SSD 7047 – Darling Harbour Integrated Display System – Response to Submissions

Government Submissions	Response
<i>Department of Planning and Environment</i>	
Third Party Advertising Further details are required for the proposed third party advertising, and in particular for 'partner info' and 'precinct partner' advertising including: ▪ mechanisms to control advertising content; and ▪ frequency and duration of third party advertising in comparison to other displays associated with signage including way finding and advertisement of events associated with the site.	In assessing this application, a certain level of planning ambiguity is caused by the requirement to define the intended use of the development through SEPP 64. In our view the Digital Content Management Plan (DCMP) (as updated) can help to address this ambiguity. Elements of the proposed development will be used for a range of uses, including: ▪ Precinct information; ▪ Wayfinding and public transit information; ▪ Promotion of public and cultural events; ▪ Health and safety information; ▪ Emergency communication; ▪ Public art; and ▪ Third party advertising Access to the proposed IDS will only be available to corporate part

C-08 Naming rights and event/precinct information

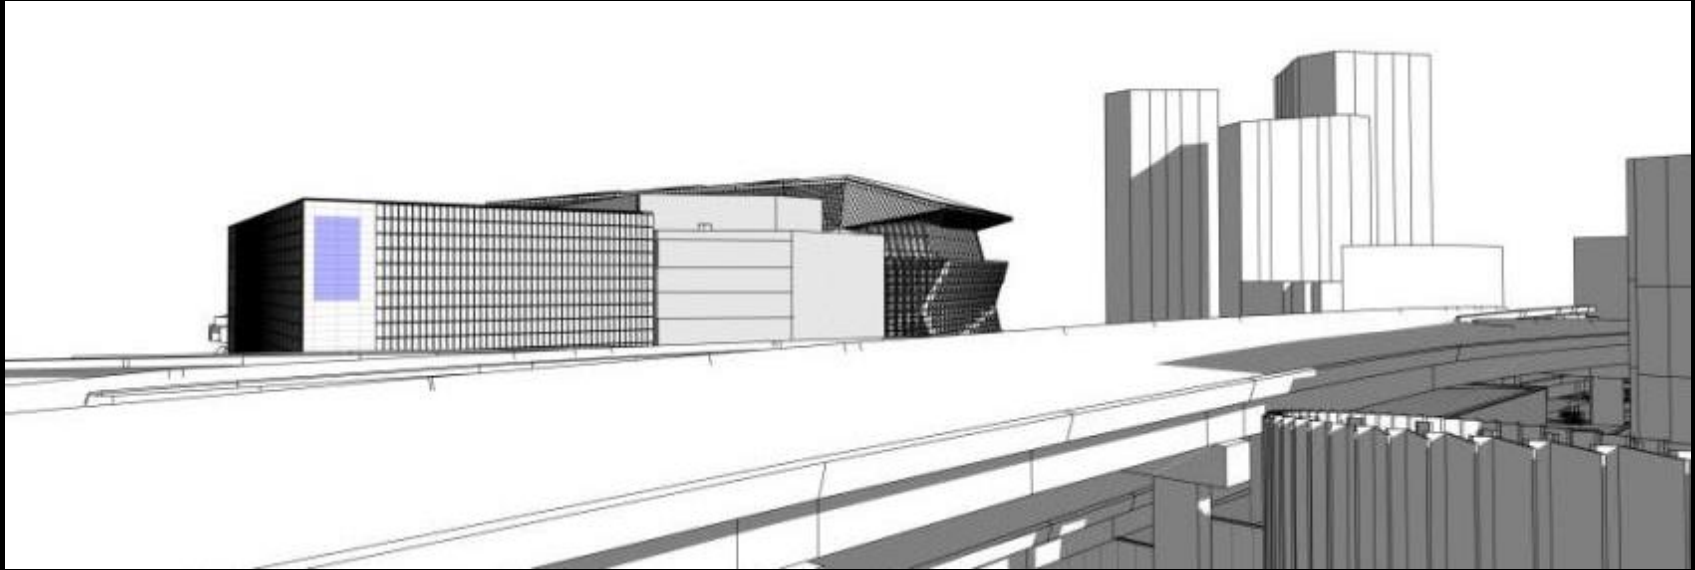
Clarification of whether signs E06 and C08 form part of the proposal is required, noting they are shown in some plans but not included in the proposal within the EIS.	C-08 and E-06 are not included in the proposed development. C-08 was included in preliminary designs for the scheme but was deleted following development of the design and in response to preliminary feedback from City of Sydney Council, RMS, and our road safety consultant. No element identified as E-06 has been considered as part of this application.
Clarification of the location and associated sign for Drawing no. CO_AR_D_440010 (Sign Ext 3.2) is required.	Drawing no. CO_AR_D_440010 (Sign Ext 3.2) relates to sign C-05, which is a static building identification sign located at the southern end of the ICC Convention Centre.
<i>Transport for NSW</i>	
Wayfinding The proposed signage should demonstrate consistency with the City of Sydney Council permanent wayfinding strategy in terms of: ▪ Naming conventions; ▪ Hierarchy of places/attractions; and ▪ Look/feel not providing confusion to customers. The CBD Wayfinding Coordination Group (CBD WCG) has been set up to facilitate this sharing of information and collaboration in wayfinding. TfNSW requests that the ongoing management of digital content is discussed as part of the CBD WCG. Shared information may be suitable for the "Public Realm" signs and include information regarding major events across the CBD (Vivid, NYE etc. which may direct to an area across agency boundaries) and disruptions (i.e. Light Rail construction or similar).	The proposed development does not include any signage which is solely 'Wayfinding Signage'. The intention of the proposed public domain Blade Signs is to augment and improve on static wayfinding signage separately provided within the Darling Harbour Precinct, as required by the development consent for SSD 5752. Indicative plans for the pedestrian and vehicular wayfinding signage that will be located within the precinct was included within Appendix B of the EIS. If required, the CBD WCG can be consulted by the Digital Content Approval Board to assist in the provision of appropriate wayfinding throughout the CBD area.

Sign C-08 The Visual Impact Assessment submitted with the application includes a LED billboard sign proposed at the southern elevation of the Convention Centre to face the Western Distributor overpass. However, there is not reference to the sign in the Development Overview of the SEE (Ref. to Table 3 on page 26). The applicant should clarify if approval for the subject sign is sought as part of the current application.	C-08 is not included in the proposed development. This element was included in preliminary designs for the scheme but was deleted. C-08 was removed from the development application following initial feedback from the project traffic safety consultant, ARRB. This iteration of the project design demonstrates the ongoing commitment to road safety.
Wayfinding It is noted that the application states that all 24 signs 'can' be used for wayfinding, however it makes no commitment to do so. Furthermore, if wayfinding is to be displayed it will only be displayed for 15% of the time. The City is of the view that this is unacceptable in this important precinct, which has exceptionally high foot traffic comprising a high number of intrastate, interstate and overseas visitors who may be unfamiliar with Sydney. It is our recommendation that some signs be allocated for permanent wayfinding. Furthermore, the dwell time for wayfinding on multipurpose signs should increase to at least 50%. The wayfinding signs should include clear information about the various hard-to-find walking links to Ultimo, Pyrmont, Haymarket and beyond, including key sites such as educational establishments and shopping precincts. We also recommend that an additional sign, with permanent wayfinding, be located near the Harris Street lift which links with Fig	Condition of consent G10 of SSD-5752 requires: <i>G 10 The development shall provide wayfinding sign age within the Subject Site in accordance with SICEEP Wayfinding and Signage Guidelines, including signage to other destinations external to the site including transport nodes and tourist destinations.</i> The intention of the proposed public domain Blade Signs is to augment and improve on static wayfinding signage separately provided within the Darling Harbour Precinct, as required by the development consent for SSD 5752. Indicative plans for the pedestrian and vehicular wayfinding signage that will be located within the precinct was included within Appendix B of the EIS. It is noted that consent is not sought for this wayfinding signage within this application.

T09 - Naming rights and event/precinct information

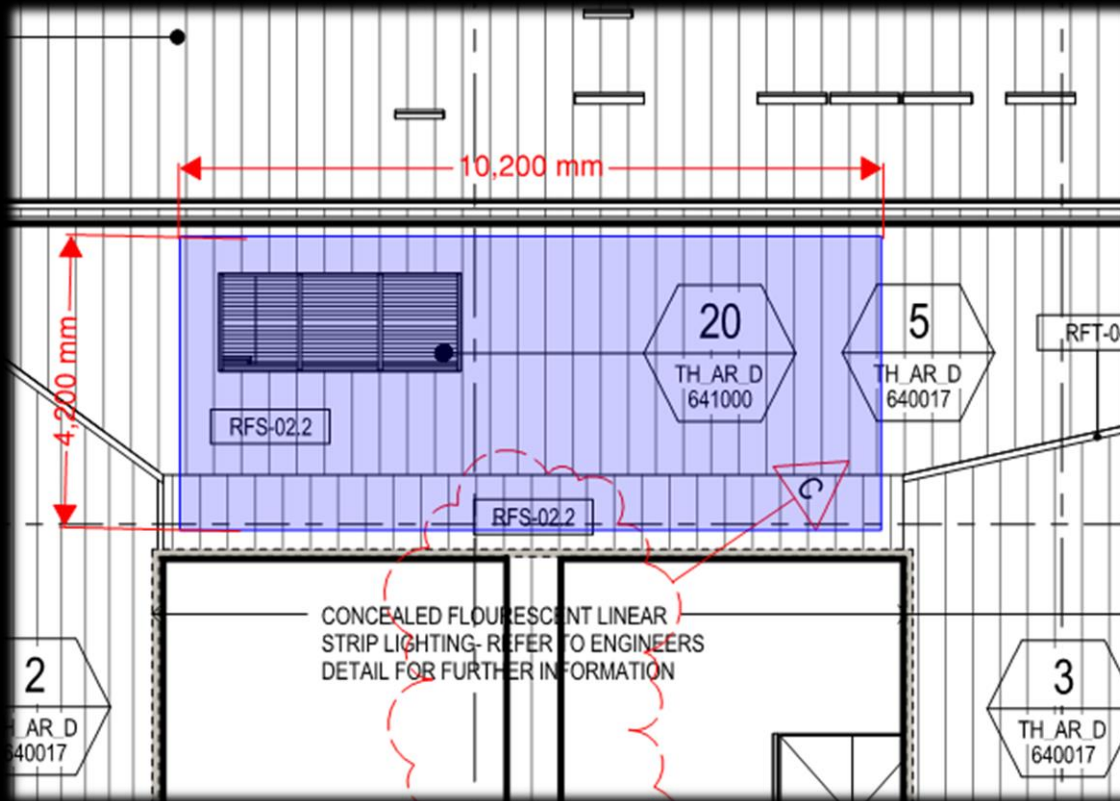
Government Submissions	Response
Clarification of the proposed purpose of building identification sign T09 is required. It is unclear why an LED display is required for building identification purposes.	LED is being used at sign T09 location as an example of 21st century signage technology. This format will allow for creative flexibility in the design of the Naming Rights partner logo. This could include advantages such as the ease of slightly altering the logo to reflect seasonal changes, colour change capabilities and the flexibility for the partner to adjust the logo for specific branding purposes. Additionally, it allows the partner to present different logos within their wider corporate structure e.g. Qantas/Jetstar/Qantas Link/Qantas Freight. LED will be a positive method to: (a) assist in attracting a very important partner to ICC Sydney; (b) maximise the commercial outcome back to The State, and (c) provide an attractive visual feature for the people of Sydney and Australia to be proud of.

Government Submissions	Response
Sign T-09 It is recommended that the applicant provide additional information regarding this sign, including the rationale for selecting an LED sign of this size and further information regarding the proposed content. If the purpose of the sign is genuinely for building identification, it is the City's view that a design similar to Building Identification Signs proposed elsewhere in the precinct would be more suitable.	LED is being used at sign T09 location as an example of 21st century signage technology. This format will allow for creative flexibility in the design of the Naming Rights partner logo. This could include advantages such as the ease of slightly altering the logo to reflect seasonal changes, colour change capabilities and the flexibility for the partner to adjust the logo for specific branding purposes. Additionally, it allows the partner to present different logos within their wider corporate structure e.g. Qantas/Jetstar/Qantas Link/Qantas Freight. LED will be a positive method to: (a) assist in attracting a very important partner to ICC Sydney,; (b) maximise the commercial outcome back to The State, and (c) provide an attractive visual feature for the people of Sydney and Australia to be proud of.
